Your Ref: OWQC23394
Our Ref: BR/121/19/L
Please ask for:
Ms M Tomalova

Listed building consent for the reinstatement of missing pieces of ornamental metalwork; redecoration of entire structure; removal of yellow brick plinth and step, and reinstatement with red brick; relocation of entrance gate from south elevation to west elevation; infilling of open east and west sides with new railing to match existing; removal of existing lighting and provision of new; fitting of horizontal ceiling; removal of concrete floor finish; laying of new non-slip tiles in geometric pattern; fitting of Perspex sheeting at high level to prevent rainwater penetration & fitting of Perspex sheeting behind balustrading to form windbreaks.

The Bandstand The Promenade Bognor Regis

A	MINOR AMENDMENT	16.04.19
REV	DESCRIPTION	DATE
PROJECT	BOGNOR REGIS BANDSTAND	
	THE ESPLANADE	
	BOGNOR REGIS	
	WEST SUSSEX	
DRAWING TITLE	PROPOSED ELEVATIONS, FLOOR PLAN AND ROOF PLAN

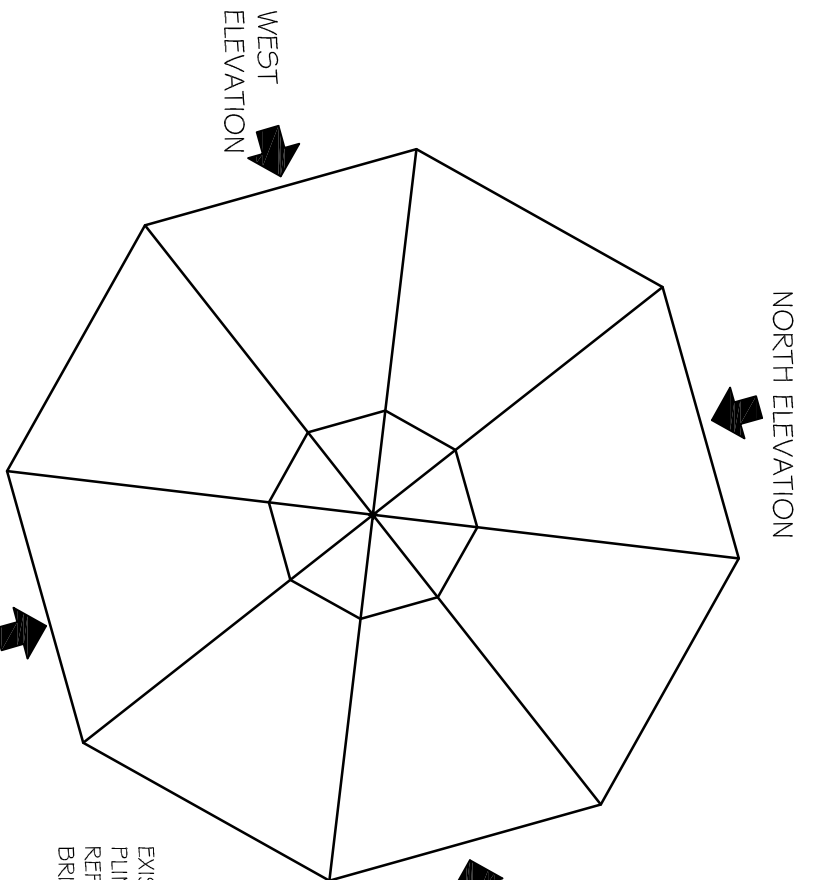
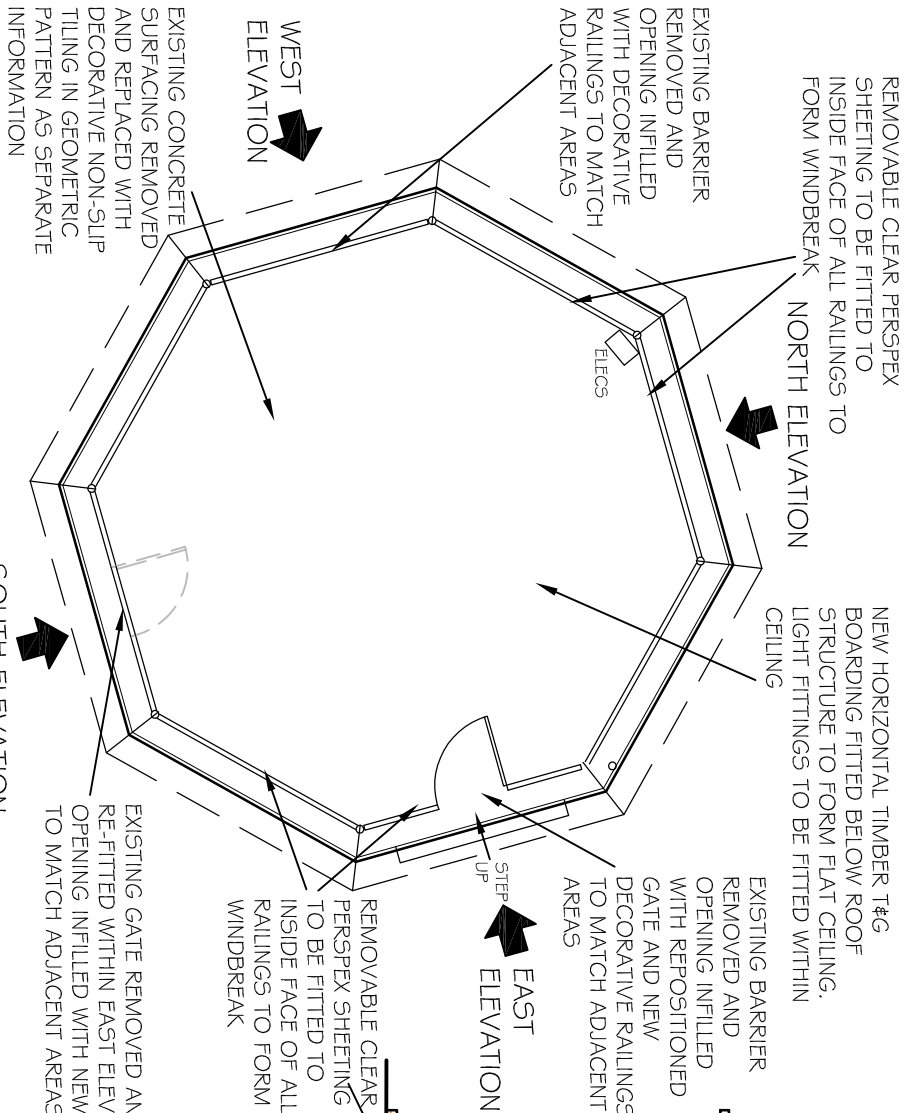
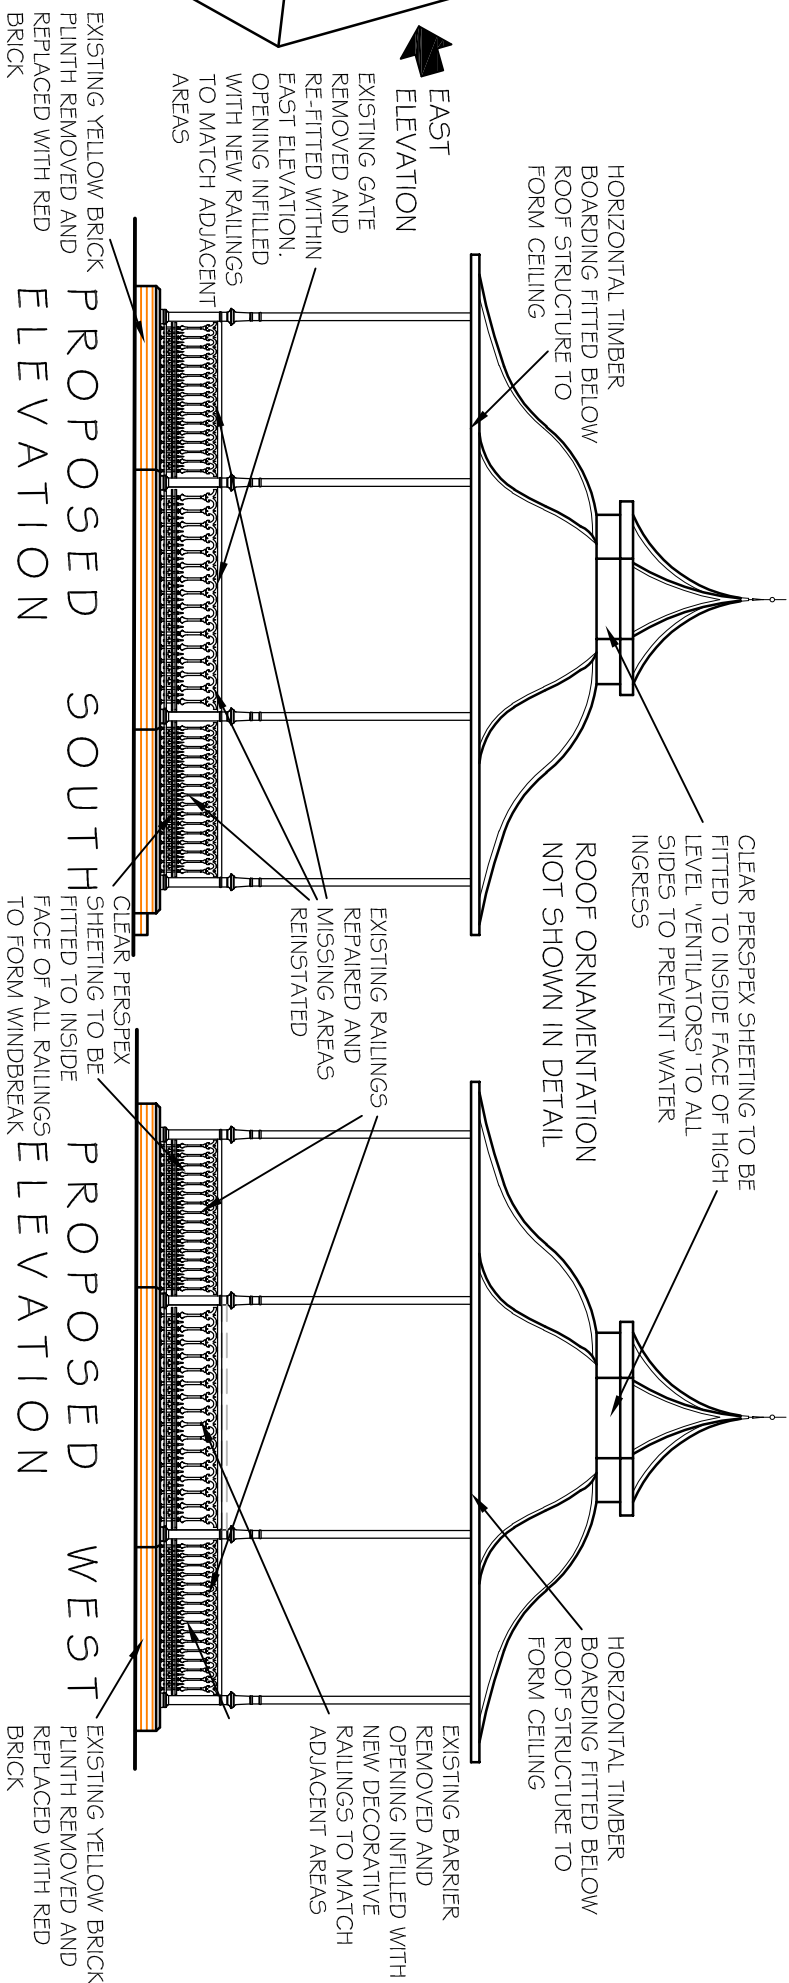
OBJECTION on the grounds of design, appearance and visual impact with particular concerns over the fitting of Perspex sheeting to The Bandstand. Members felt that insufficient design details were provided, with reference to the proposed Perspex sheeting, to enable them to be satisfied that these alterations and repairs would be in keeping with the Listed Building and not contrary to policies D DM4 and HER DM1 of the Arun Local Plan.
